Bild Responses

Preliminary Review	
Transportation	a. Impact on Surrounding Street Systems	<ul style="list-style-type: none"> 	<ul style="list-style-type: none">
	b. Access and Circulation	<ul style="list-style-type: none"> Need turning templates showing that parking area at rear will function adequately Rear door appears to be located in close proximity to parking space, where there is potential for conflict between pedestrians exiting the building and cars. What about door swing? Concern re FHA accessibility and the legibility of building entrances. Ideally, the front entrance would be accessible. Further comments on this will be forthcoming. Concern re utility of front entrance for guest/resident access. Wayfinding is an issue. 	<ul style="list-style-type: none"> Turing templates are attached. The 17.7 foot radius is reflects the published turning radius of a Toyota Prius and Honda Civic. Door has been adjusted to swing in. No further changes will be made until parking layout is finalized and accepted. The accessibility & way-finding narrative has been revised and is attached. Response to comment found in accessibility and way-finding narrative

SUBDIVISION REVIEW (14-497)

PERVIOUS PAVEMENT SECTION DETAIL
NOT TO SCALE

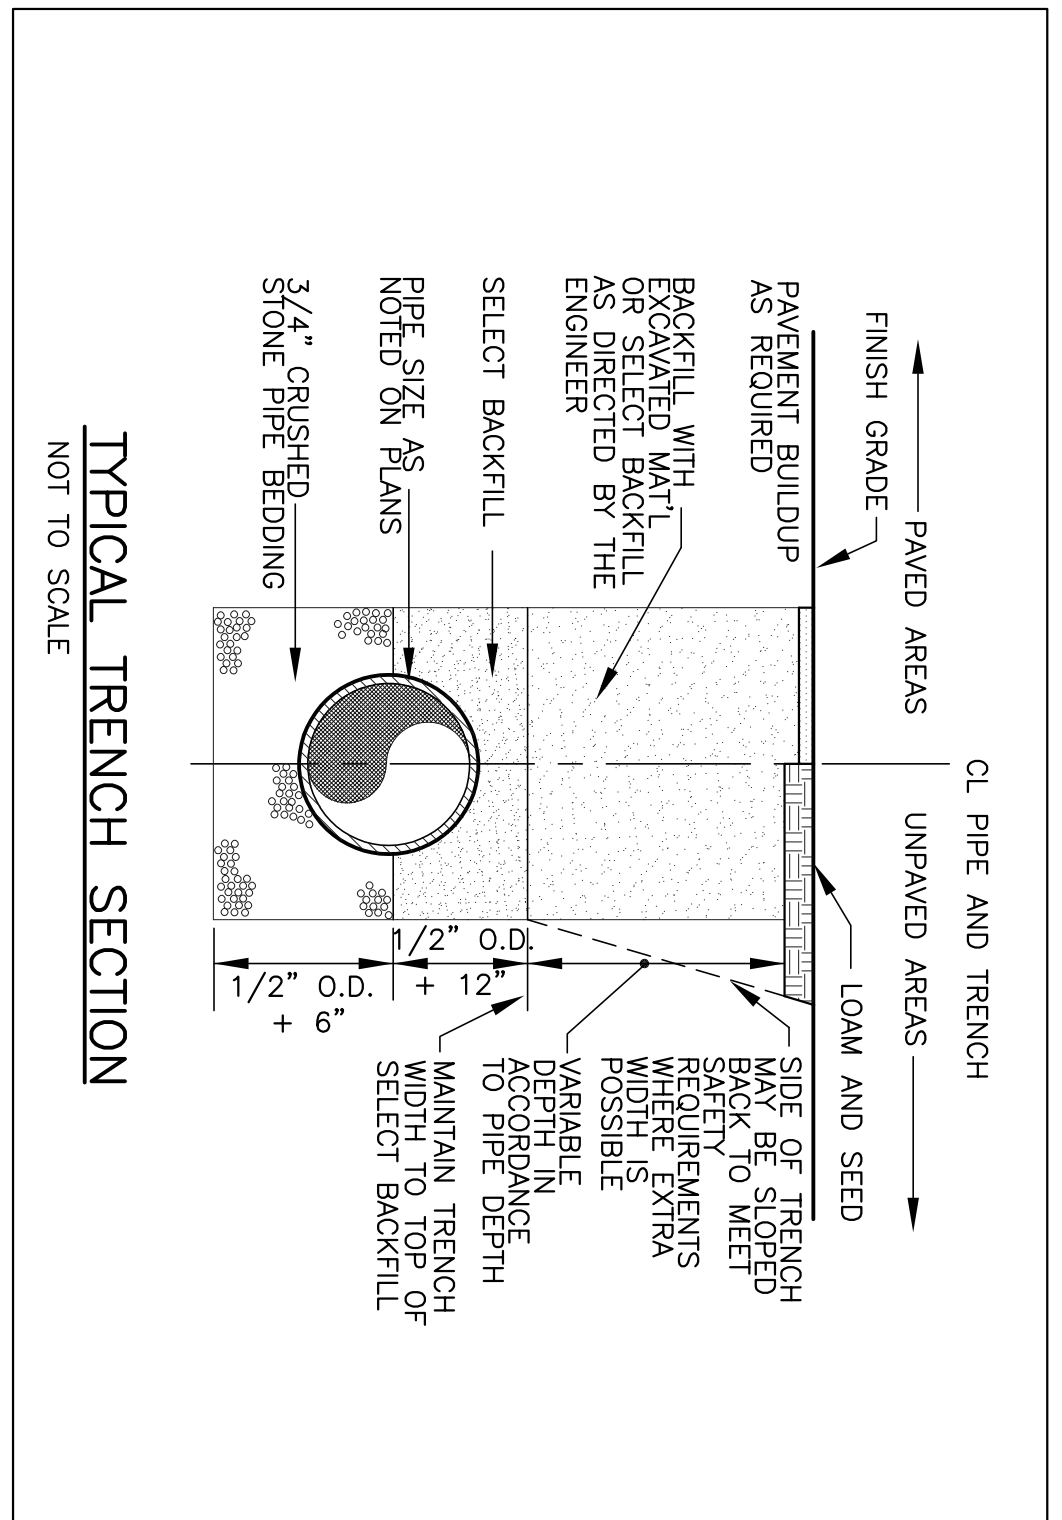
c. Water Quality, Storm Water Management and Erosion Control	<ul style="list-style-type: none"> Are pervious pavers proposed within the center of the driveway or within all of the parking area? The stormwater report and plan appear to conflict Based on response to above, confirm impervious calculations. Calculations in stormwater report appear to assume that entire parking area and driveway are pervious Show where stormwater is proposed to enter the city's system 	<ul style="list-style-type: none"> The pavers are within all of the parking area. This will be updated on the site plan in separate response from civil engineer. See above. Stormwater runoff will flow overland to the existing stormdrain system within Merrill Street once the pervious pavement treatment system is over capacity.
Public Infrastructure and Community Safety	a. Consistency with Master Plans	<ul style="list-style-type: none">

BICYCLE RACK SPECIFICATION - BIKE HITCH

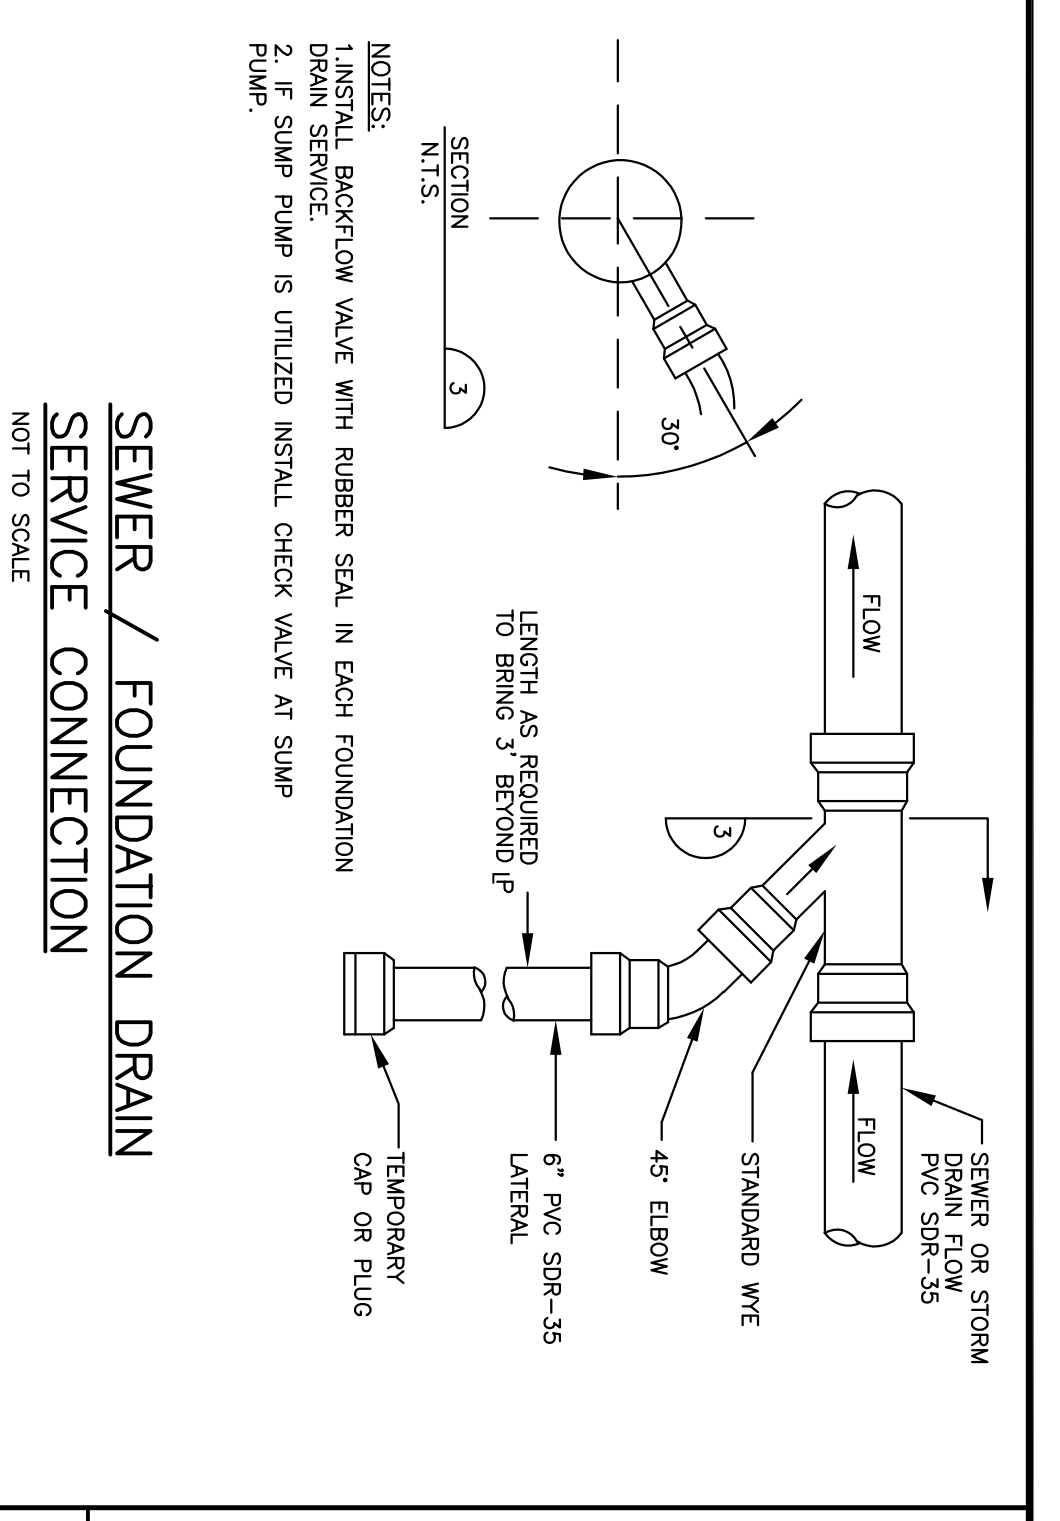
c. Public Transit Access	<ul style="list-style-type: none"> N/A 	
	d. Parking	<ul style="list-style-type: none"> <i>Bike parking standard: Residential – 2 spaces/5 dwelling units = 3 bike parking spaces. Please show rack on plan and include detail.</i> Snow storage area will be inaccessible when cars are parked. Please revise or provide alternate plan for snow storage/removal. 	<ul style="list-style-type: none"> Bike rack for (2) bicycles provided on sidewalk in site plan for public use. Location of front door and access to basement storage compartments is intended to give residents ample personal storage to be used for bicycles as needed. Snow storage will be addressed in separate response from civil engineer.
